Trinity Grammar School Redevelopment (SSD-10371) - Notice of Exhibition

Thank you for your correspondence via the Major Projects Portal on 5 May 2020, requesting Transport for NSW (TfNSW) to review and comment on the above.

DRAWING TITLE  
**ENTRY / EXIT DELIVERY DRIVEWAY MANOEUVRES  
DESIGN VEHICLE - MRV**

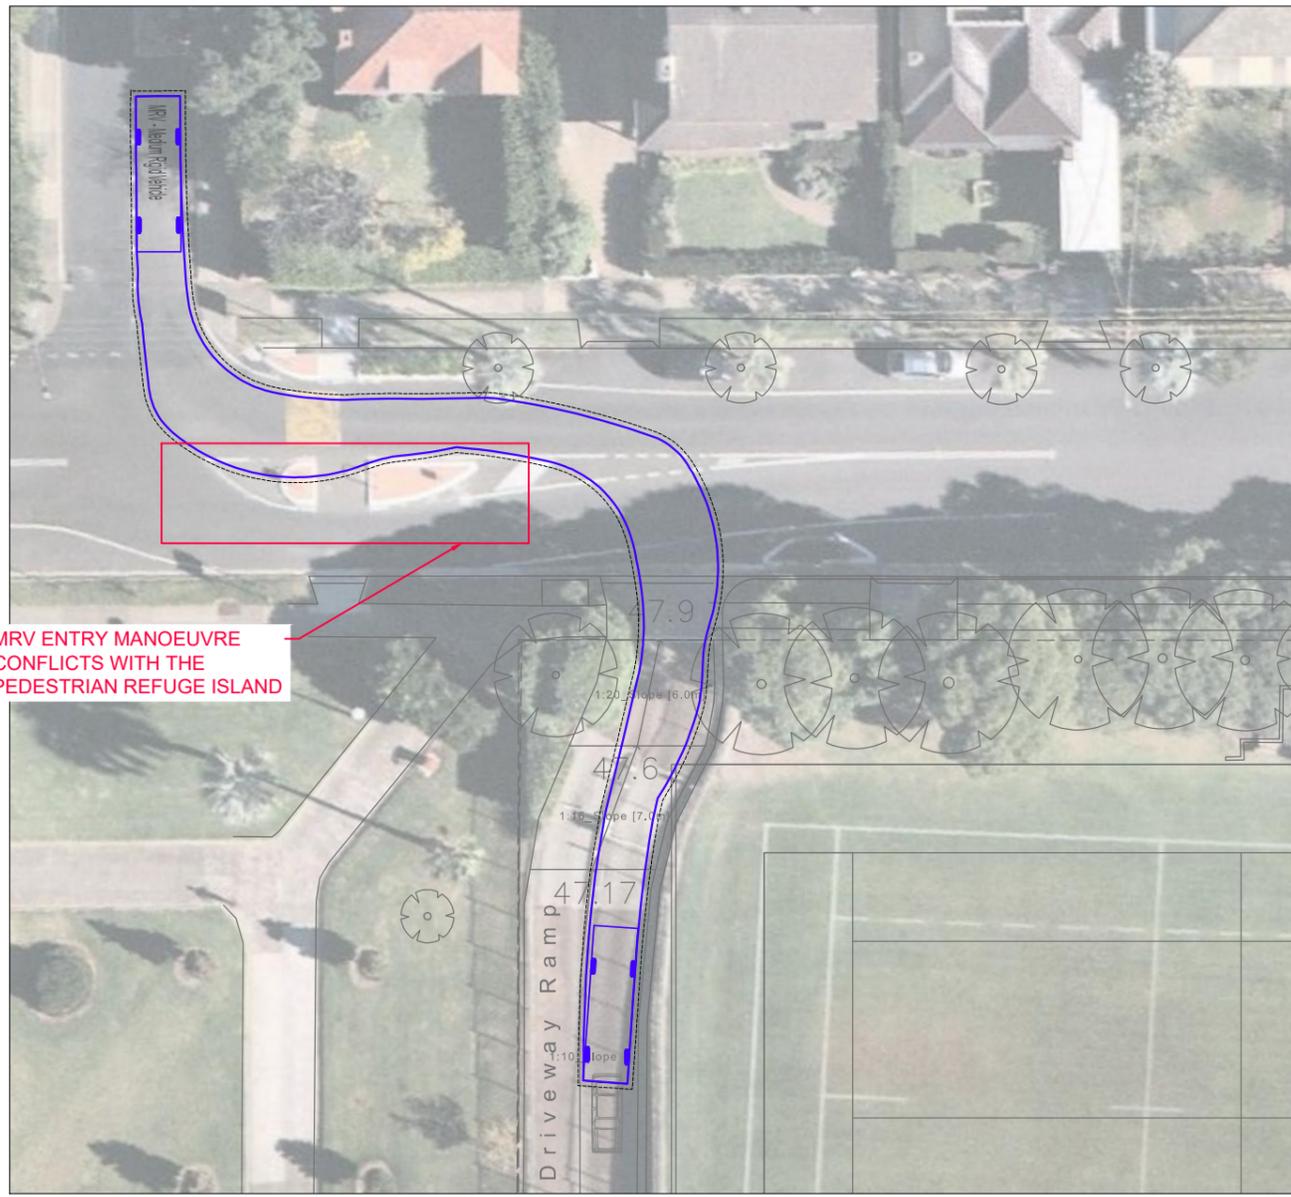
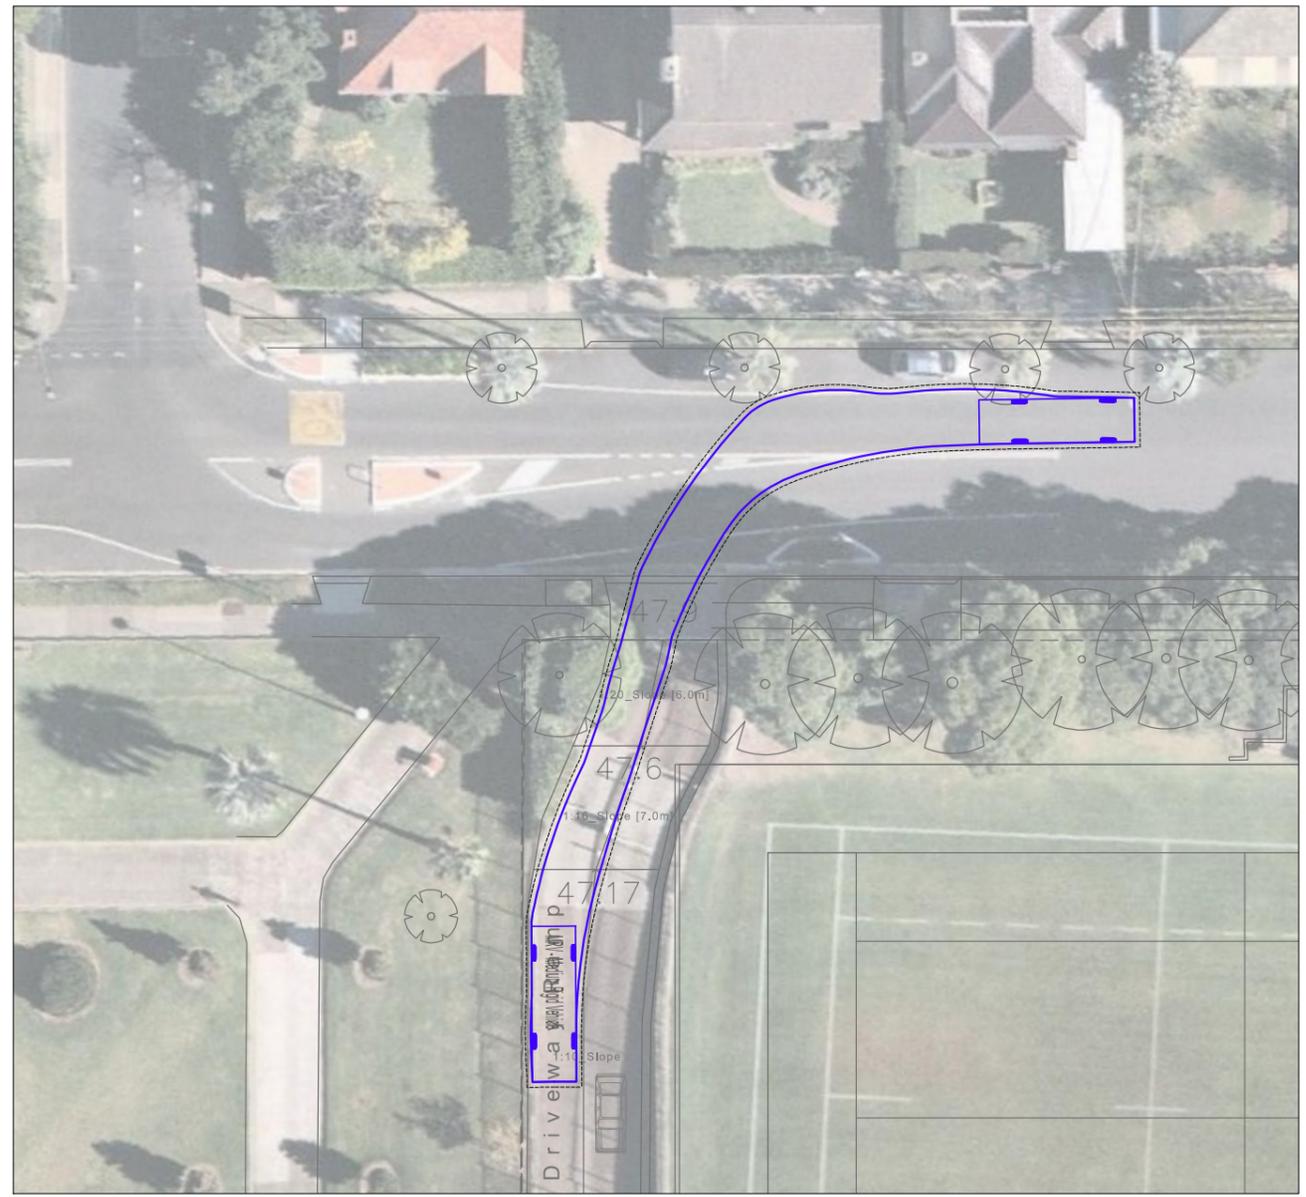
The Transport and Accessibility Assessment prepared to support the development application states that Medium Rigid Vehicles (MRV) and Heavy Rigid Vehicles (HRV) entry manoeuvres conflicts with the pedestrian refuge island on Victoria Street.

It is advised that the proposed replacement of pedestrian refuge island with a painted island on Victoria Street would have an impact on the pedestrian safety in particular for school children crossing Victoria Street.

- The applicant be conditioned to undertake a Stage 2 (Concept Plan) Road Safety Audit in accordance with the relevant Austroads Guidelines by an independent TfNSW accredited road safety auditor for the following:
 - Proposed painted island in replacement of the pedestrian refuge on Victoria Street; and
 - Proposed delivery vehicle access arrangement for Southern Access Road on Victoria Street.

Based on the results of the road safety audit, the applicant shall review the design drawings and implement safety measures in consultation with the local council as required.
